Subject: RE: 11 Dalloway Road

DRAWING TYPE  
PROPOSED FIRST FLOOR PLAN

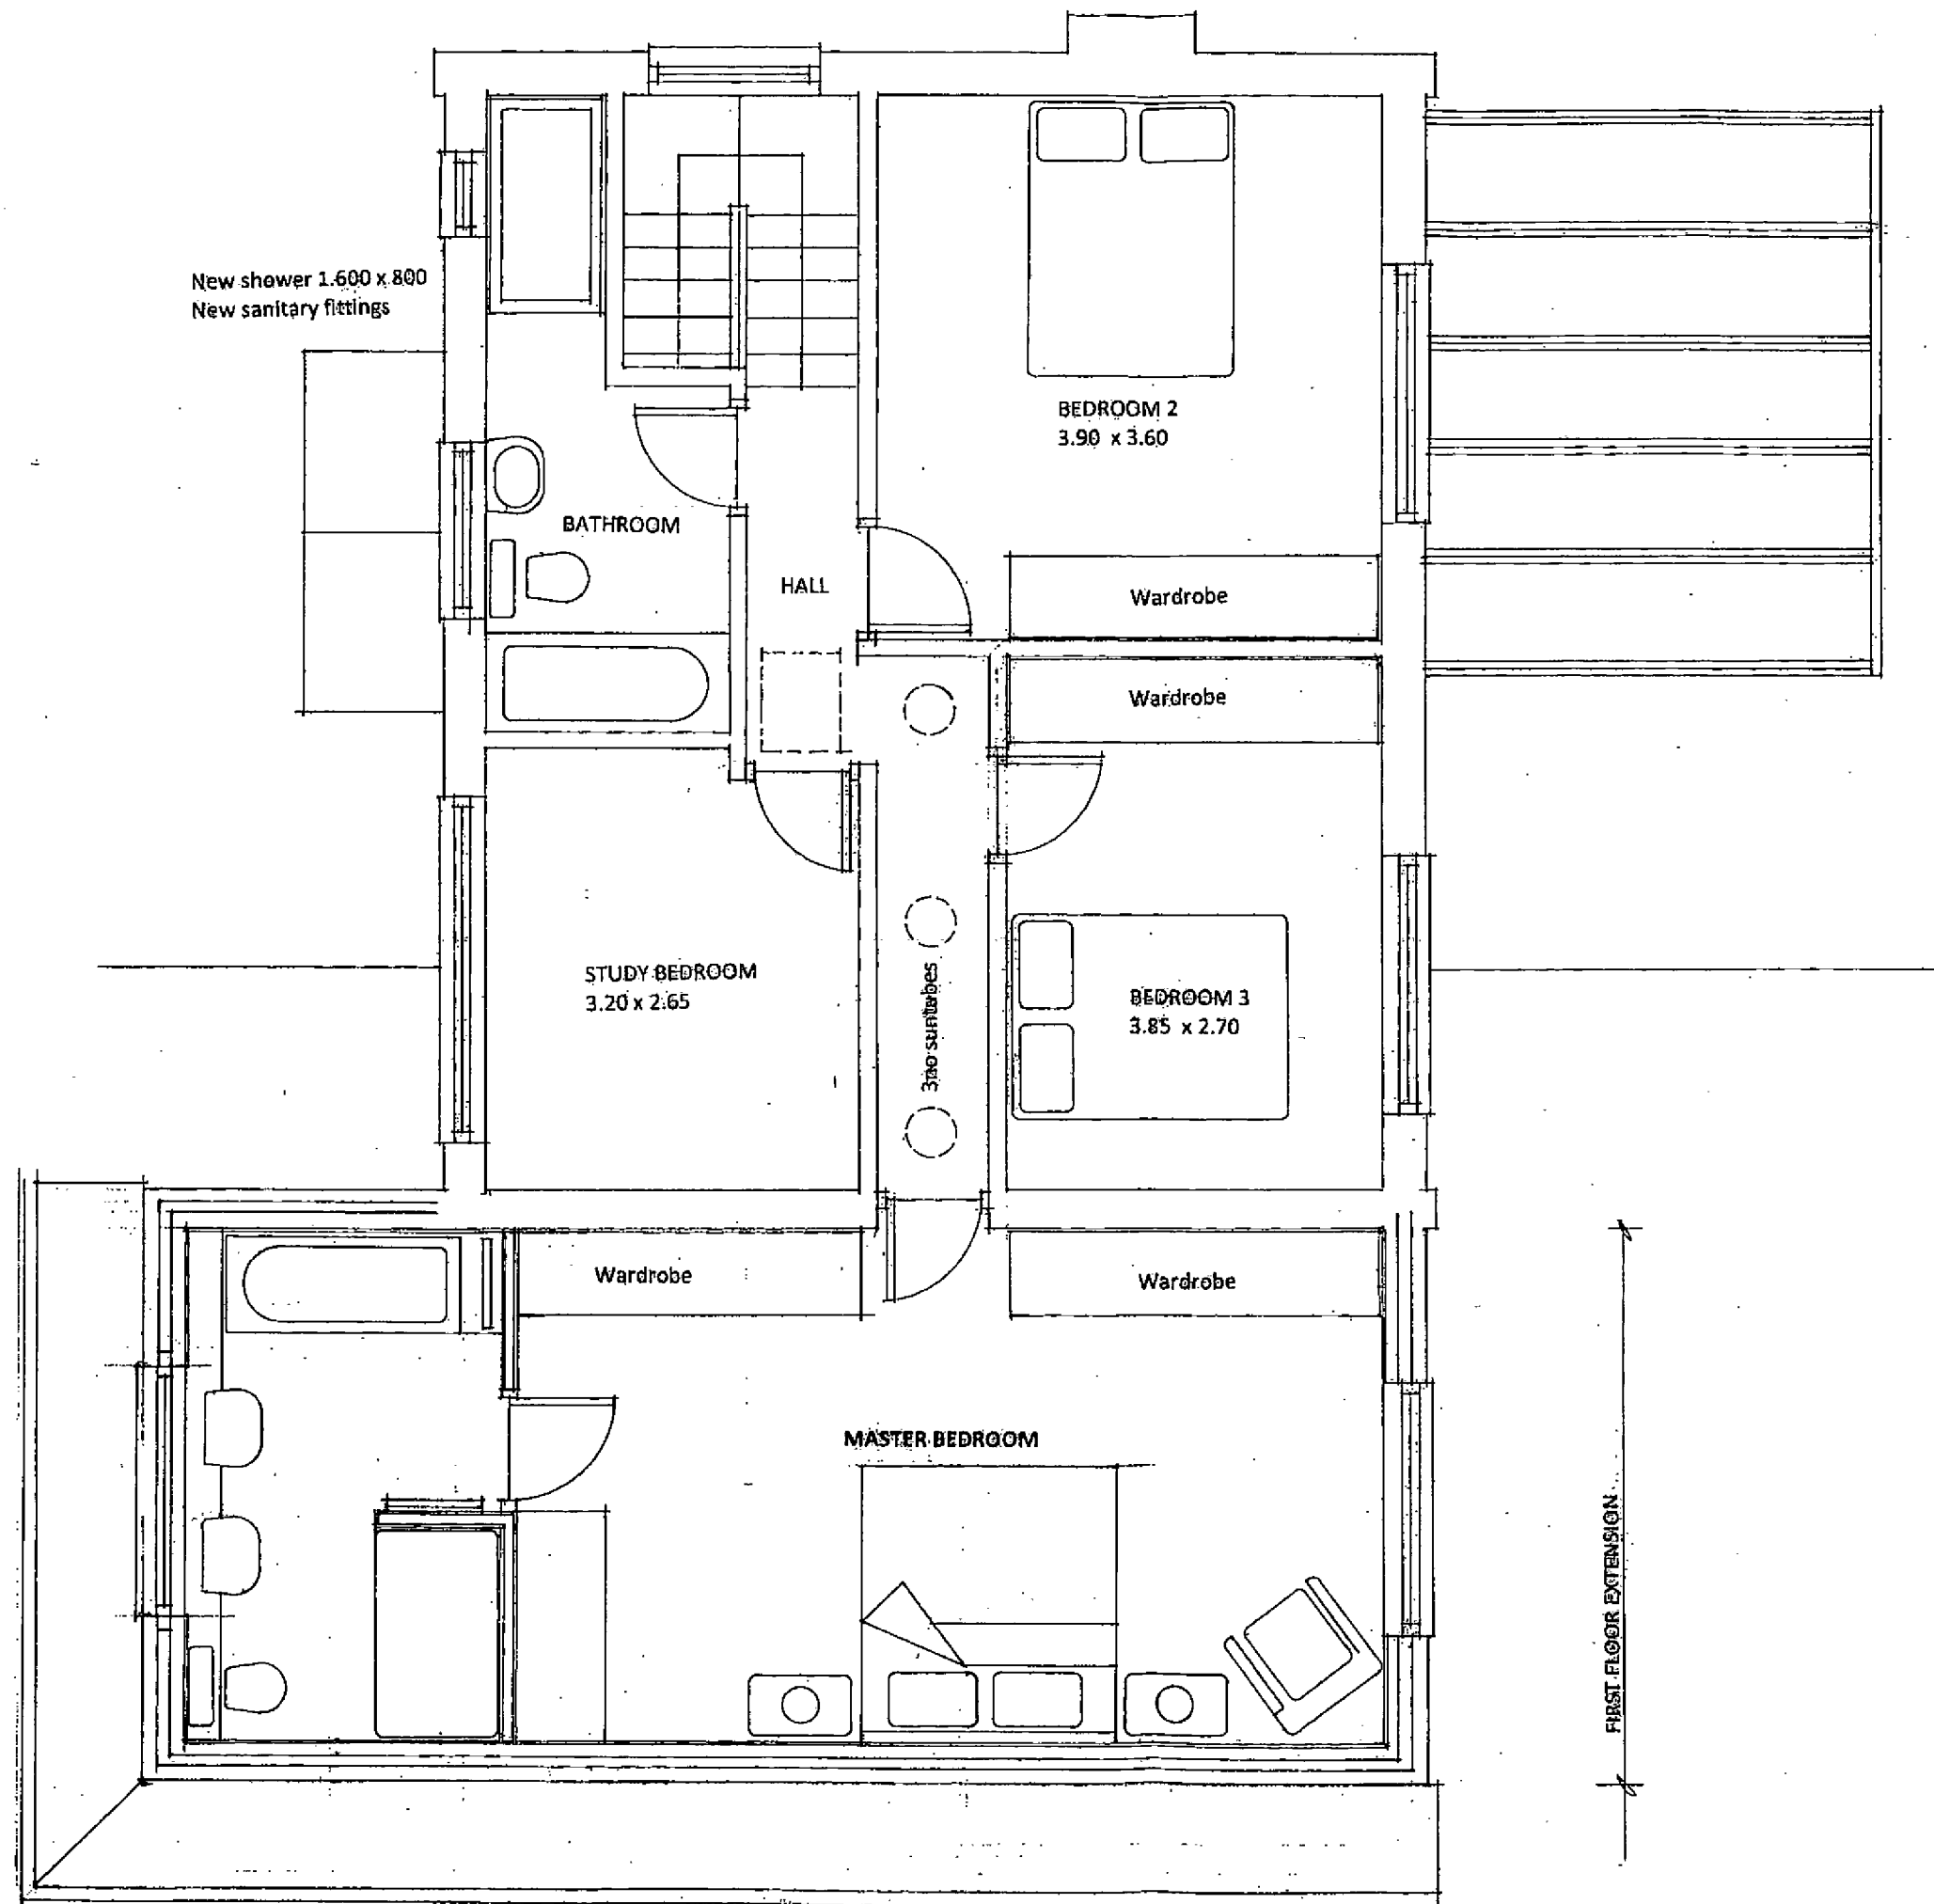
The revisions look to be more acceptable, subject to the distance shown between the 1st floor addition being at least 1 metre from the shared boundary.
